Your Ref: 100663135-002
Our Ref: 24/00588/LBC

Date 22nd March 2024

Application No: 24/00588/LBC
Proposal: Listed building consent for internal alterations to include conversion of bar to store and installation of internal doors and chimney vent, replacement of ceiling, radiators, and removal of cabinet with associated plasterwork, painting and refurbishment works
Address: St Andrews Town Hall Queens Gardens St Andrews Fife KY16 9TA

FOYER DOORWAY ELEVATION - AS PROPOSED
1 : 50

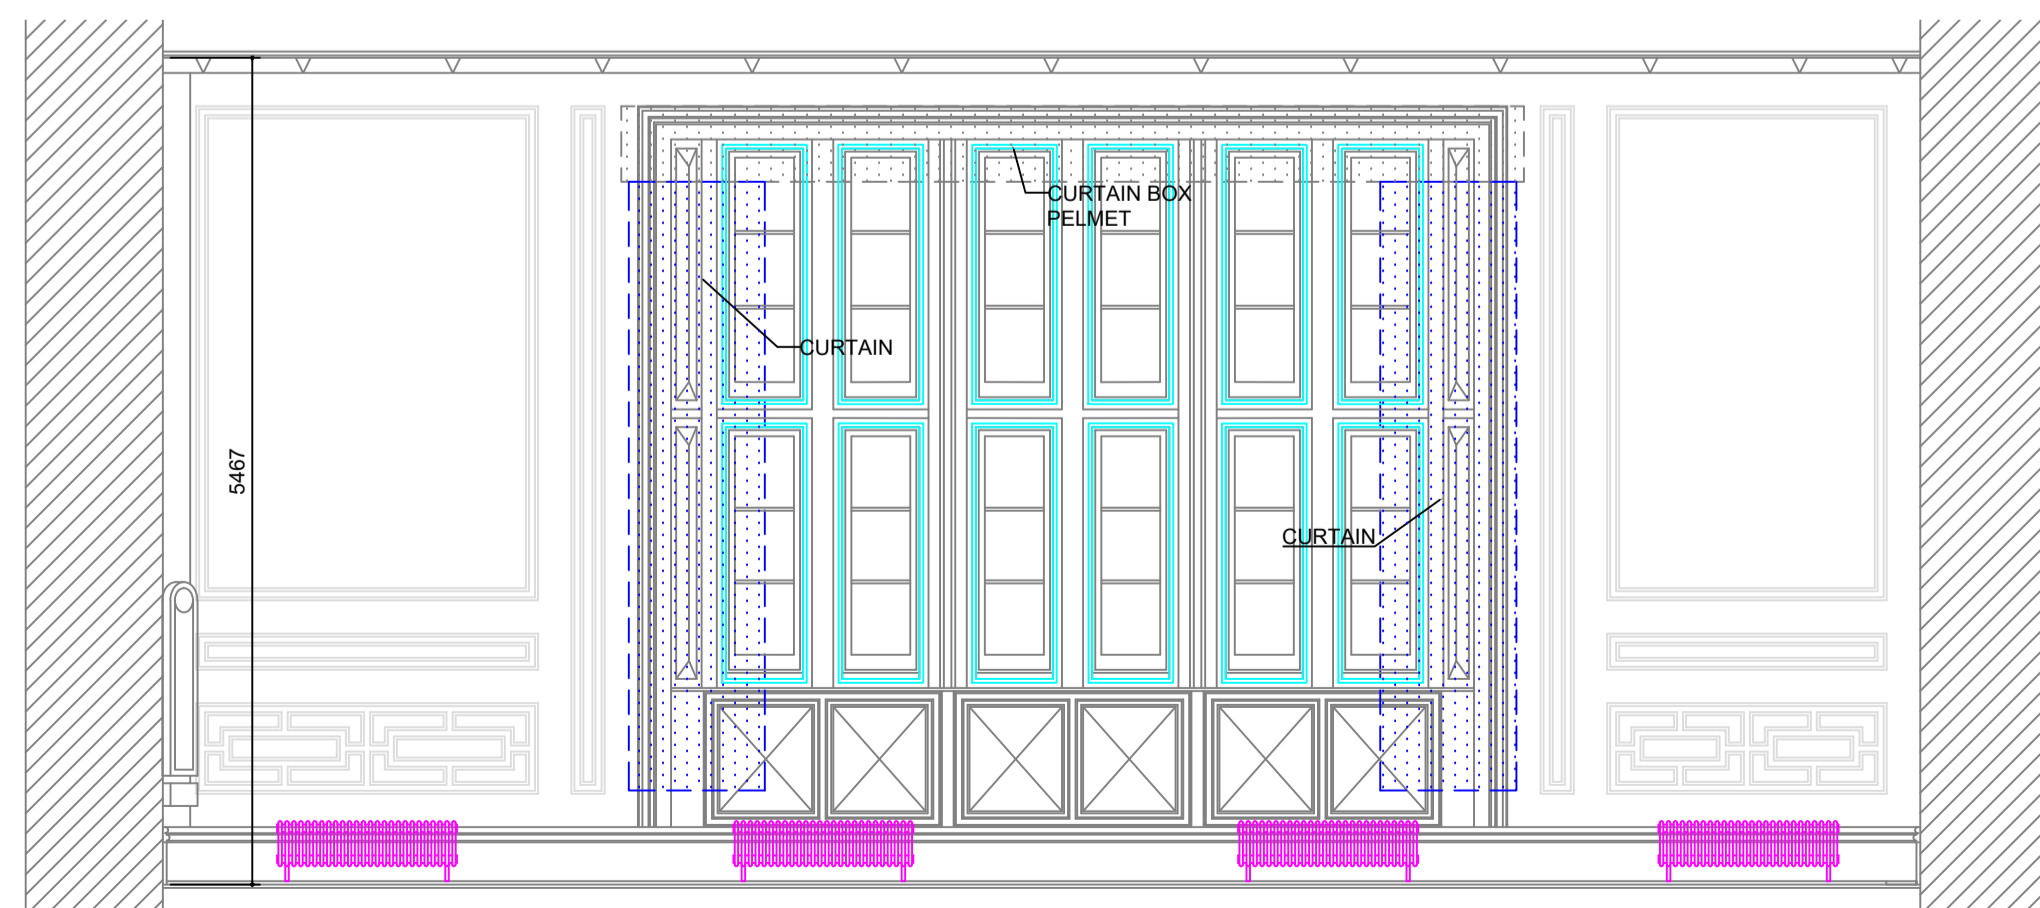
2. Please provide existing internal elevations to compare against the proposed elevations as submitted. For clarity this is to understand the differences between the old and new radiators and given that the radiator detail is not to scale.
